FOSSE GREEN ENERGY DEVELOPMENT CONSENT ORDER

PINS REFERENCE EN010154

**DEADLINE 2: NATIONAL HIGHWAYS'
COMMENTS ON SUBMISSIONS MADE BY THE
APPLICANT AT DEADLINE 1 AND RESPONSE
TO ExA FIRST WRITTEN QUESTIONS**

**PROPOSED TYPICAL TRENCHLESS CROSSING CROSS SECTION B-B**

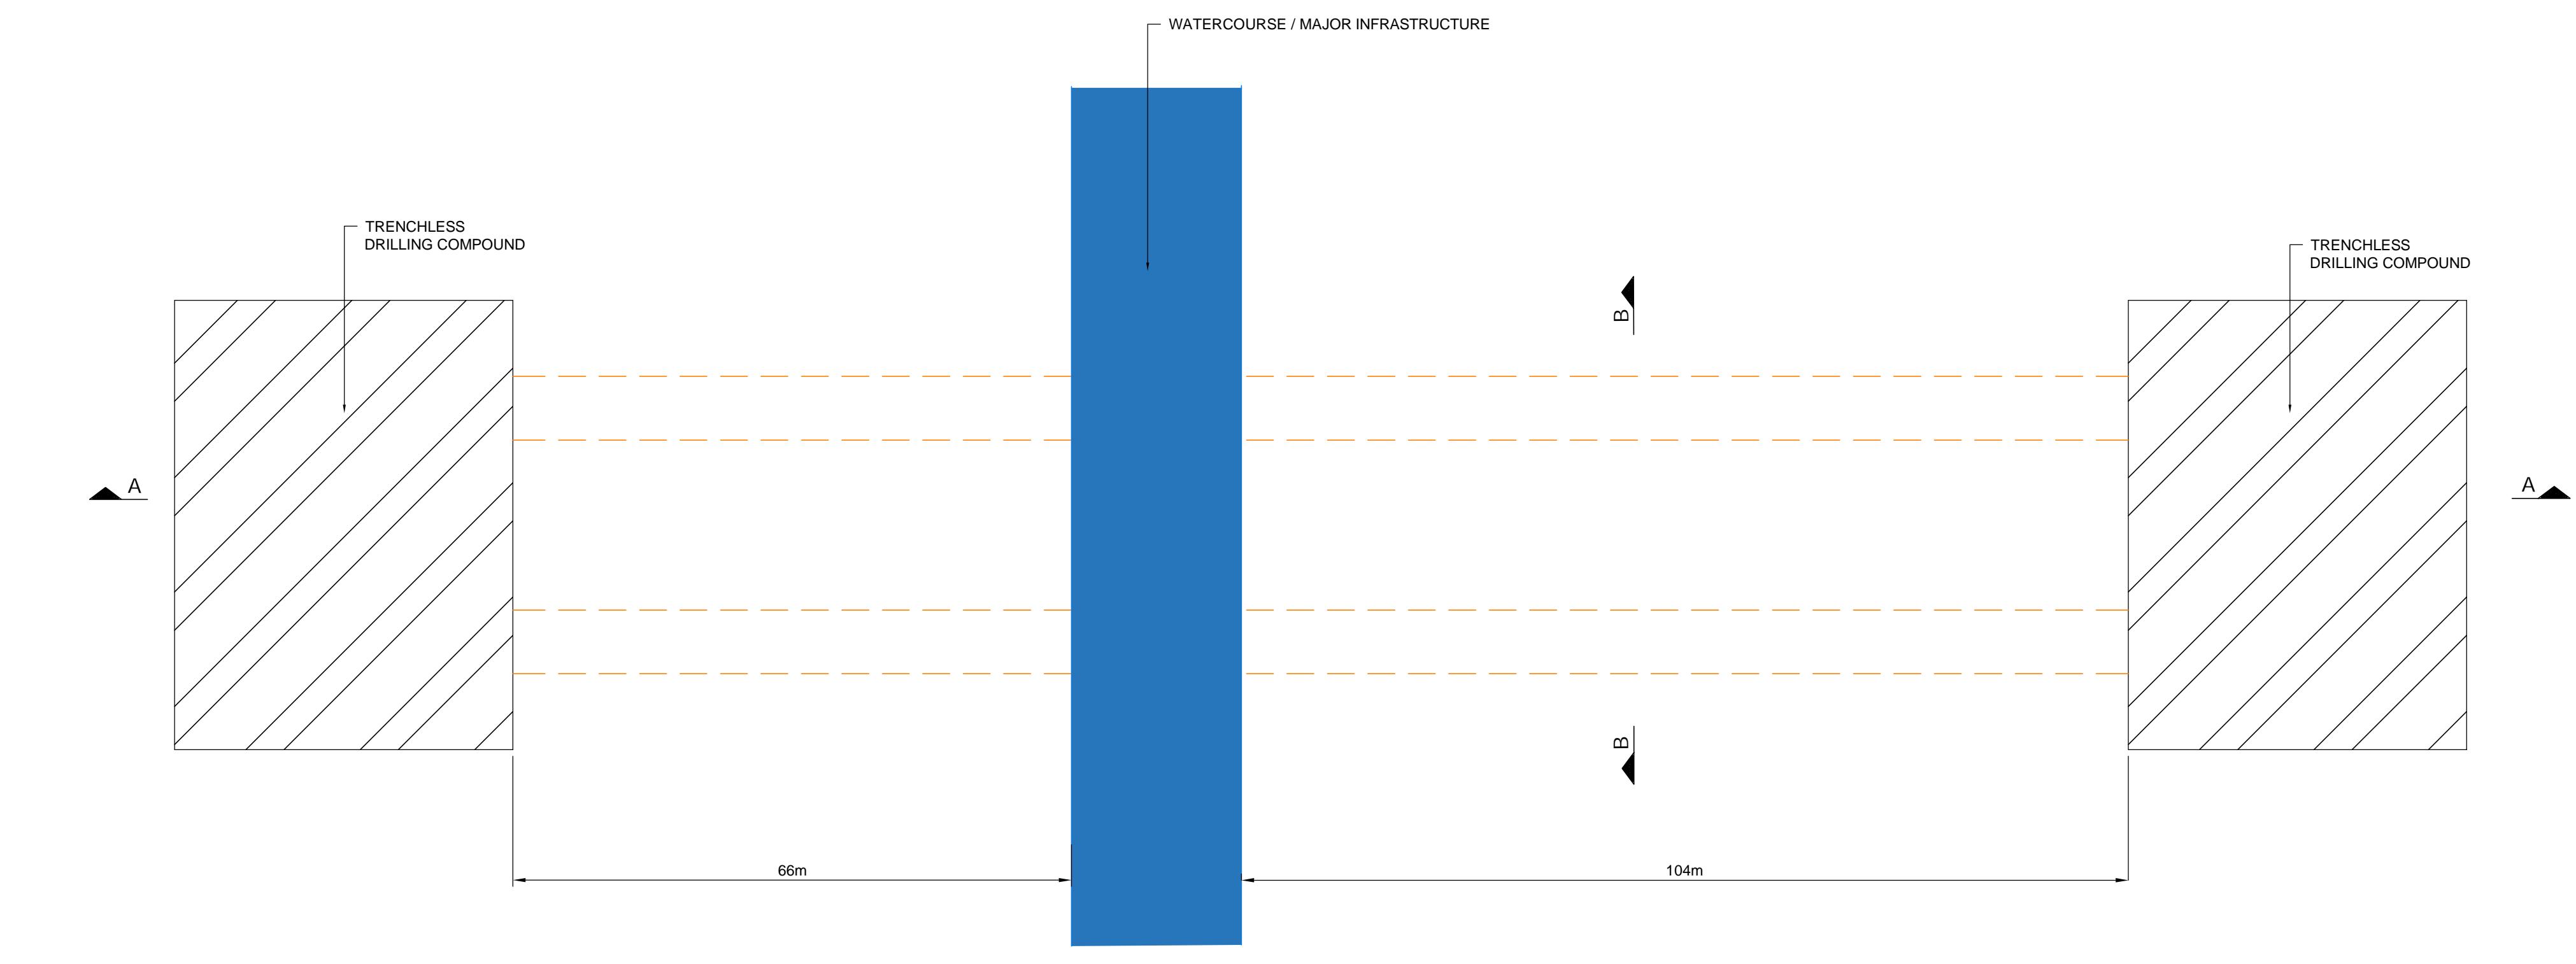
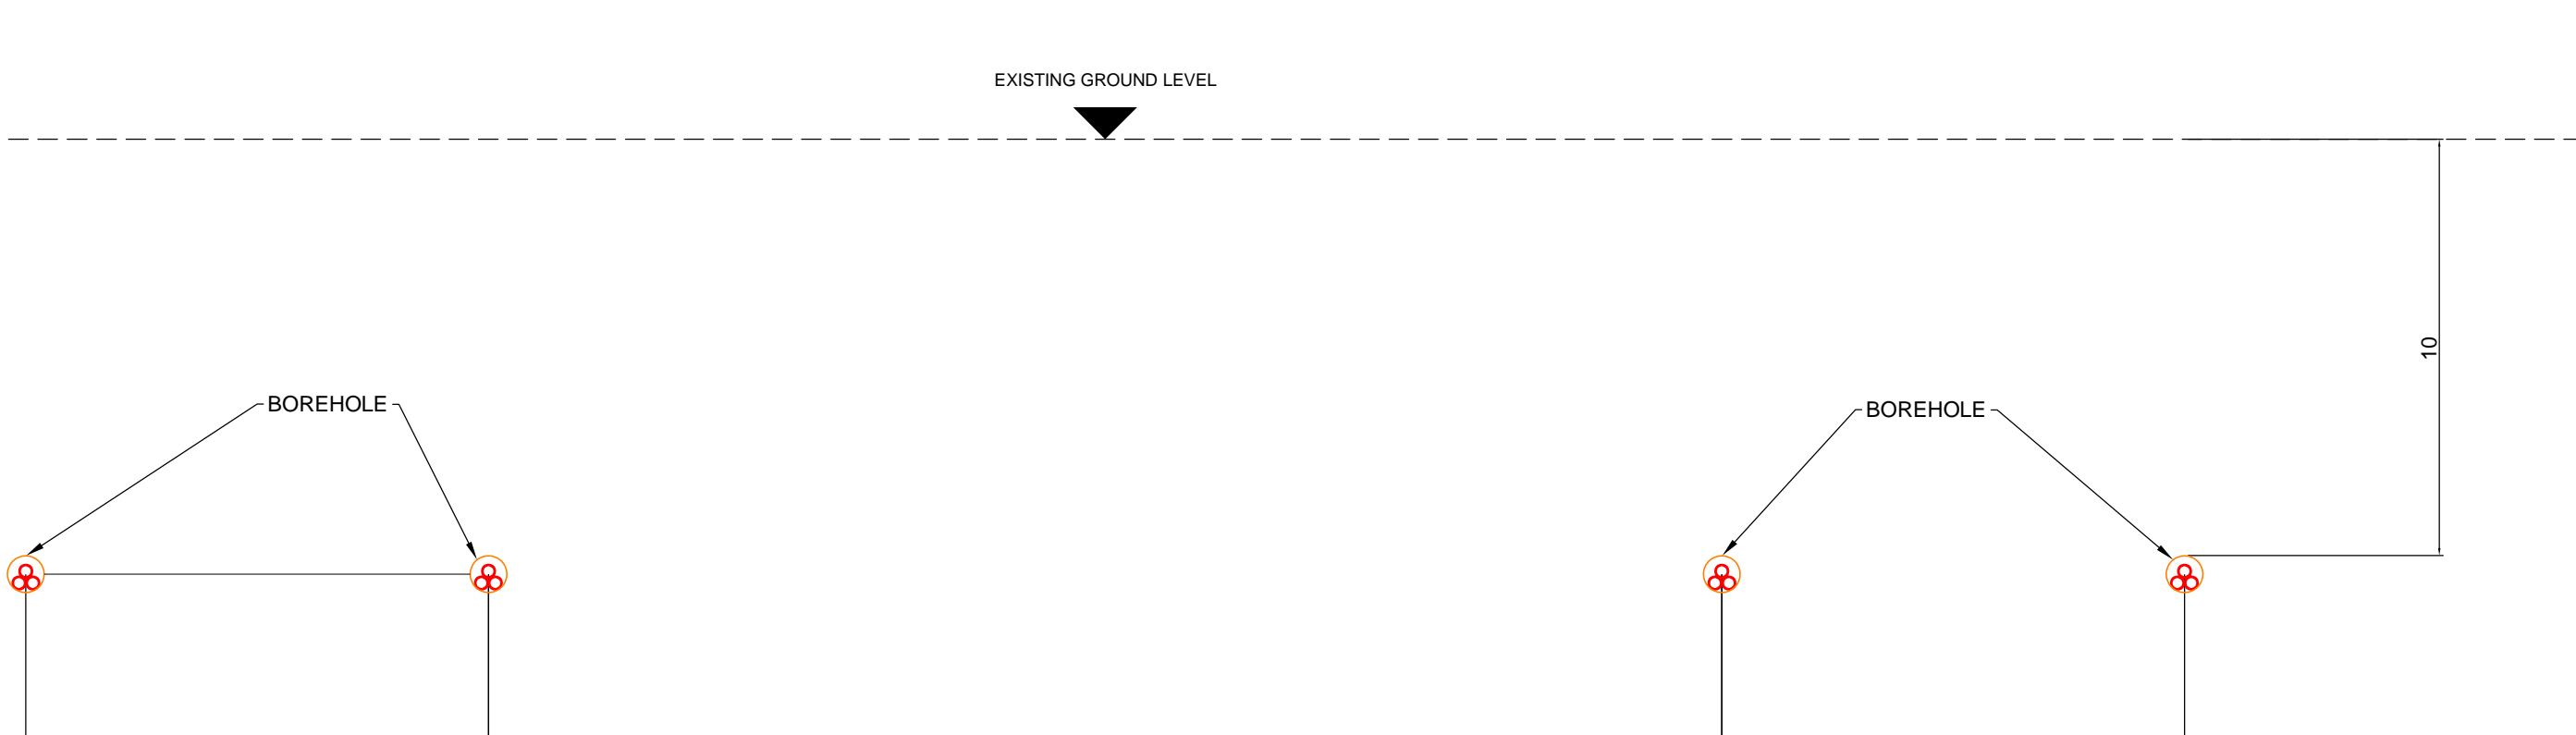
2	<p>Protecting SRN</p> <p>The impact of works number 6 and 9 on the SRN</p> <p>The Authorised Development is situated to the south-west of Lincoln. Bisecting the north of the site is the A46 trunk road, which is a dual carriageway subject to the national speed limit that forms part of the SRN. We note there will be interaction with the A46, at Work Numbers 6 and 9 which involves the laying of electrical cables under the SRN.</p>	<p>Two trenchless crossing locations, as indicatively shown in Figure 3-12: Indicative Trenchless Crossing Locations of the ES [AS-028], are proposed due to the wide area that the cables originate from. This will decrease the concentration of cables in one area and reduce the overall cable lengths required.</p> <p>The Applicant will work with NH regarding the location of the A46 crossings through the production of a feasibility study for these works. As requested by NH, this will include provision of further information on:</p>	<p>We will continue to work collaboratively with the Applicant on matters relating to the Trenchless crossing locations and protective provisions for technical approvals. We will provide the ExA with an update on the protective provisions negotiations at the next deadline.</p> <p>Additionally, at this stage and before NH can remove its concern in this regard, NH would like to understand if consideration has been given to a single crossing, as this</p>

<p>11</p>	<p>Draft DCO</p> <p>Article 8</p> <p>(1)the Applicant may enter on so much of any of the streets specified in Schedule 4 (streets subject to street works) and may— (a) break up or open the street, or any sewer, drain or tunnel under it; (b) drill, tunnel or bore under the street; (c) place and keep apparatus under the street; (d) maintain, change the position of or remove apparatus under the street; (e) repair, replace or otherwise alter the surface or structure of the street or any culvert under the street; and (f) execute any works required for or incidental to any works referred to in sub-paragraphs (a) to (e).</p> <p>It is NH's understanding that all known street works should have been included in Schedule 4 given that there is not catch all provision under article 8. It is however noted that the works proposed to be carried out beneath the SRN (A46) shown on the Indicative Trenchless Crossing Locations document (APP-059) are not included within that schedule. Any works taking place under the SRN (such as tunnelling for a pipeline) are street works pursuant to the New Roads and Street Works Act 1991 (NRSWA). Such works cannot take place without the street authority's approval. Section 51 of NRSWA provides:</p> <p>Prohibition of unauthorised street works. (1) It is an offence for a person other than the street authority— (a) to place apparatus in a street, or (b) to break up or open a street, or a sewer, drain or tunnel under it, or to tunnel or bore under a street, for the purpose of placing, inspecting, maintaining, adjusting, repairing, altering or renewing apparatus, or of changing the position of apparatus or removing it, otherwise than in pursuance of a statutory right or a street works licence.</p> <p>The word "in" is defined with the NRSWA under section 105 as follows: Minor Definitions in a context referring to works, apparatus or other property in a street or other place includes a reference to works, apparatus or other property under, over, across, along or upon it</p> <p>The definition of "in", which is used to in section 51 NRSWA, makes it clear this would also apply to apparatus under the SRN. Whilst we note the Applicant is seeking to acquire rights over land beneath the SRN, given that the apparatus is beneath the highway surface powers under article 8 are also required to ensure an offence is not committed under section 51 NRSWA. Given the depth of the apparatus a 2 stage process is required; the need for both the street works authority under NRSWA and the land rights.</p>	<p>Article 8</p> <p>The Applicant agrees that the proposed crossing points under the A46 should be included in Schedule 4 of the Draft DCO [APP-016]. However, as National Highways will appreciate, the exact crossing points have not yet been determined, and will not be until the detailed design stage, which will be undertaken post-consent. Therefore, the Applicant proposes inserting the following wording into Schedule 4 of the Draft DCO [APP-016] - "those parts of the A46 that are within the limits of deviation of Work No. 6" with the description of the street works being "Street works to facilitate underground cable installation works for the length of the A46 shown in green patterned hatching on Sheet 4 of the streets, rights of way and access plans". The Draft DCO [APP-016] and the Streets, Rights of Way and Access Plans [AS-106] have been updated to reflect these amendments and will be submitted to the Examination at the next available examination deadline.</p>	<p>NH are content for the Applicant's proposed wording within this response and amendments made to Schedule 4 of the dDCO (REP1-007), subject to agreement of the NH's Protective Provisions. The protective provisions would seek to protect NH assets whilst the applicant is exercising powers pursuant to article 8.</p>

To address National Highways concerns, we would request the Applicant updates Schedule 4 to include the crossing points on the A46.		
12	<p><u>Requirement 4 approved details and amendments to them</u></p> <p>(1) With respect to any documents, details or schemes which have been approved pursuant to any requirement (the “Approved Documents, Plans, Details or Schemes”), the undertaker may submit to the relevant planning authority and to National Highways where any amendments effect the strategic road network or land National Highways have an interest in for approval any amendments to any of the approved Documents, Plans, Details or Schemes and, following approval by the relevant planning authority, the relevant Approved Documents, Plans, Details or Schemes are to be taken to include the amendments as so approved pursuant to this paragraph.</p> <p>(2) Approval under sub-paragraph (1) for the amendments to any of the approved Documents, Plans, Details or Schemes must not be given except where it has been demonstrated to the satisfaction of the relevant planning authority and National Highways where the amendments effect the strategic road network or land National Highways have an interest in that the subject matter of the approval sought is unlikely to give rise to any materially new or materially different environmental effects from those assessed in the environmental statement.</p> <p>In addition to the approval of the Local Planning Authority, National Highways approval should be sought where any amendments to documents, details or schemes effect the SRN or land National Highways has an interest in. For any variations to the approved documents and plans, NH must ensure that changes do not adversely impact the SRN, namely the A46 Trunk Road. This is in the interest of maintaining the safe and efficient operation of the SRN.</p> <p>Inclusion of drafting in red would address NH’s concern</p>	<p><u>Requirement 4 approved details and amendments to them</u></p> <p>The Applicant proposes to include a new sub-paragraph to Requirement 4 of Schedule 2 to the Draft DCO [APP-016] as follows:</p> <p>“(2) In determining whether to approve any amendments to any of the approved Documents, Plans, Details or Schemes, the relevant planning authority must re-consult all consultees that were required to be consulted on those Documents, Plans, Details or Schemes when those Documents, Plans, Details or Schemes were originally approved.”</p> <p>The Draft DCO [APP-016] will be submitted to the Examination at the next available examination deadline.</p>	NH are agreeable to the Applicant’s proposed wording within this response and note the Applicant has updated dDCO at Schedule 2 (REP1-007). NH concern is addressed in this regard
